City of Albuquerque Stormwater Construction Site Inspection Report

ESC File No.	H17E097A	Project Name:	Burger King		
NPDES Id. No.	NMR1004E4 NMR1004DZ	Location:	2110 Carlisle Blvd. NE		
2/17/2022	Owner	Contractor			
Operator	M&M Brothers	PJ Development, Inc.			
Contact name & title	Tom McCollum	Pat Joseph			
e-mail	tmgmtmmm@aol.com	pat@pjdev.net			
Contact Phone #	861-7474	263-6965			
COA Inspector	Doug Hughes	Start/End Time:	4pm		
Construction Phase:	Excavation/grading				
Type of Inspection:	<input checked="" type="checkbox"/> Regular	<input type="checkbox"/> Storm Event	<input type="checkbox"/> Past Storm Event >0.25"	<input type="checkbox"/> 311/Complaint	<input type="checkbox"/> Follow Up
Weather at time of inspection?		clear		Temperature: ~	50
Estimated date of last storm 0.25" or greater		1/1/2022

TEMPORARY EROSION AND SEDIMENT CONTROL PLAN

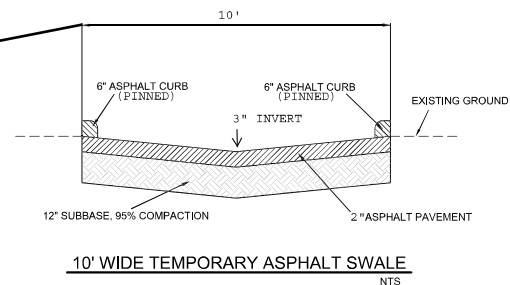
Item Number	Deficiency/ Corrective Action				
1	The NPDES permit coverage wasn't posted. It must be posted for sfe public viewing.				
2	The SWPPP wasn't available onsite, and there was no indication onsite ast its location. The up-to-date SWPPP must be available onsite.				
3	Trackout sediment in the street and on paved common entrance shared with Carlisle crossing. Sediment the same day it is tracked out.				
4	Inlet protection next to Carlisle entrance needs maintenance and trackout pad missing.				
5	Silt fence was not toed in and has a gap at the bottom. Mulch sock needed around low side of site.				
6
